Re: Planning Application AW/360/14/HH
91 The Fairway, Aldwick Bay
Side Extension for garage & store with guest suite.

The house is situated within the 'Aldwick Bay' designated Conservation Area and with this in mind the Board confirm as follows:

SITE PLAN 1-500

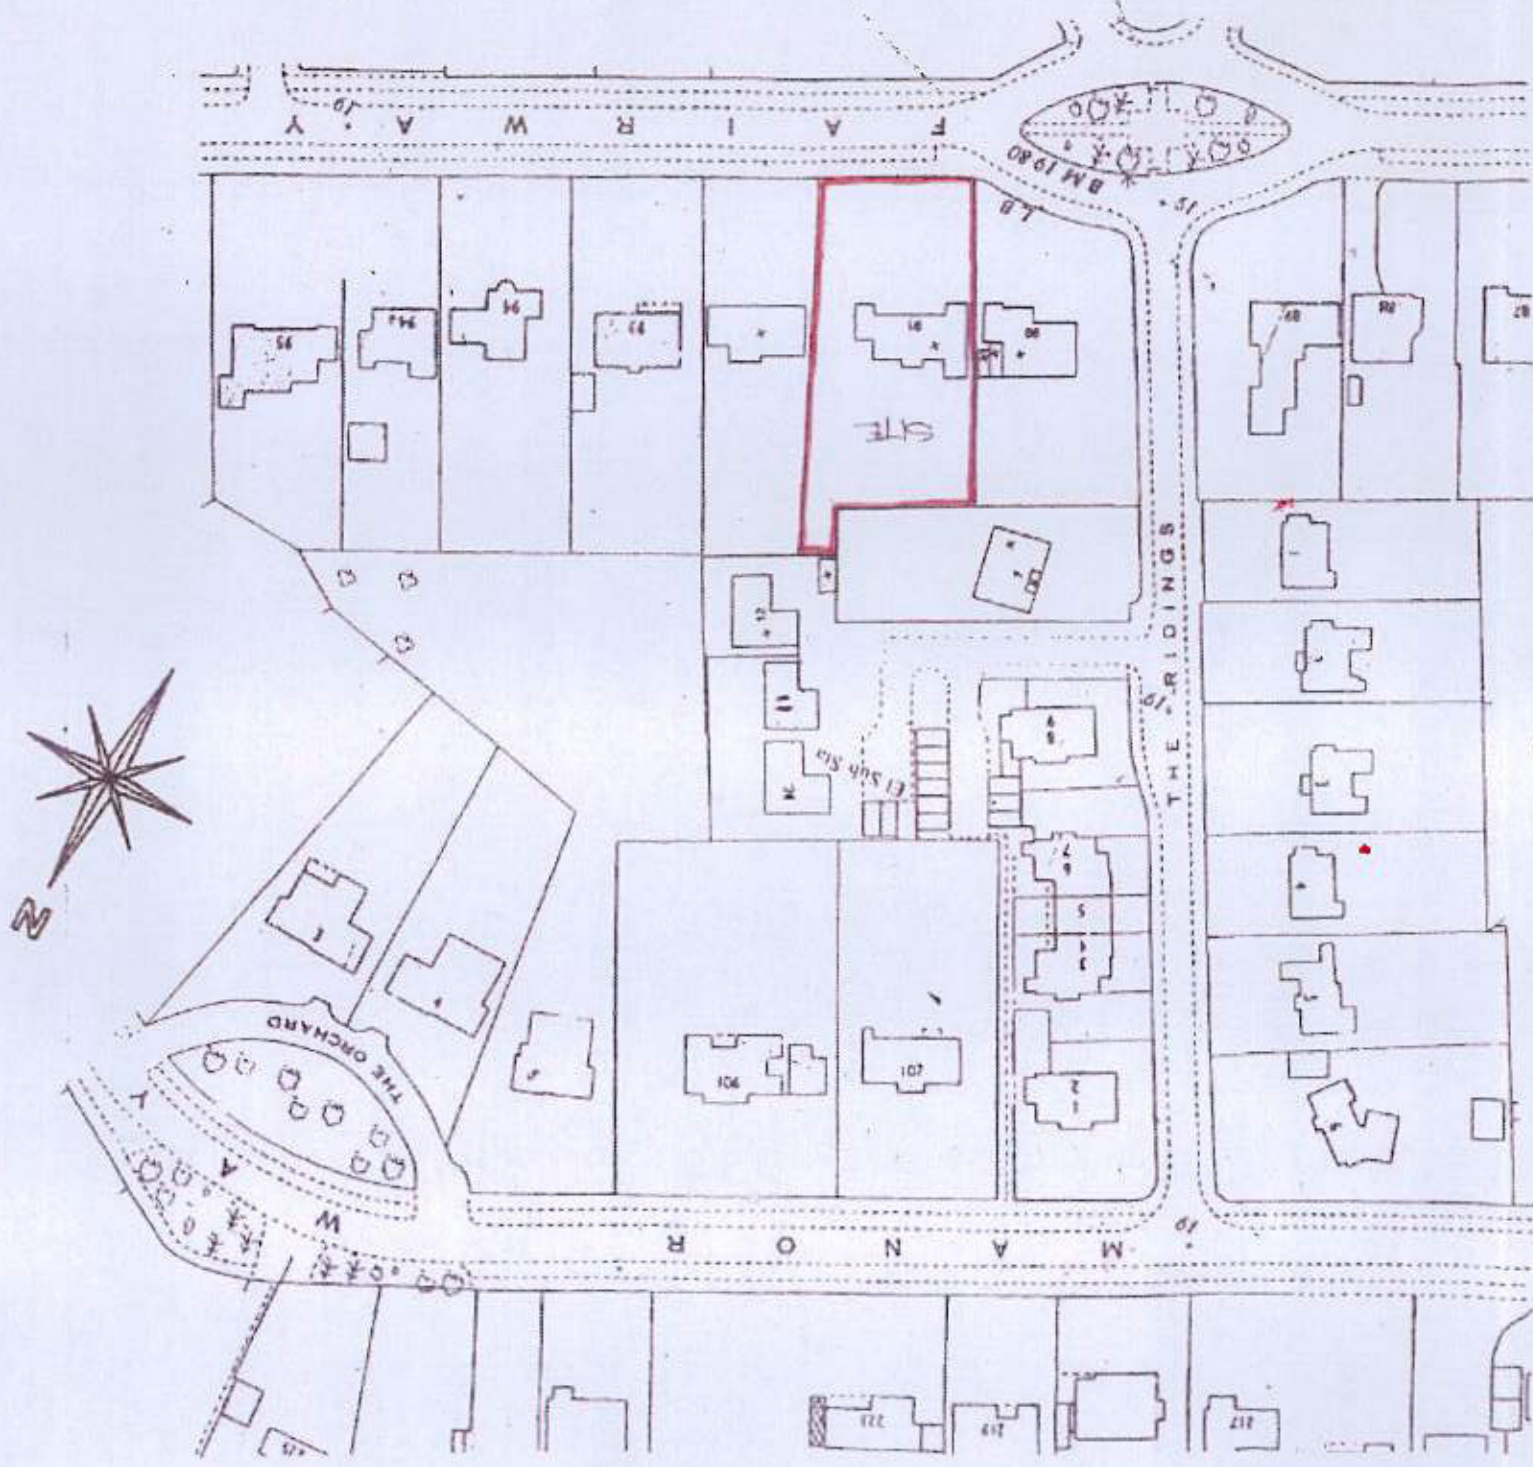
1. There is a tall hedge along the east boundary, made up of conifers/shrubs/trees which is not shown on the site plan. This will be affected by the proposed extensions. The drawings should show the position and width of the hedge and varieties and to what extent it is going to be removed/retained/replaced.
2. The rear of the extension is 2 storeys high and may affect the incoming light of the adjoining garden and house to the east, 92 The Fairway.
3. The new bathroom window to the east should be frosted glass and fixed below 1.7m above floor level.
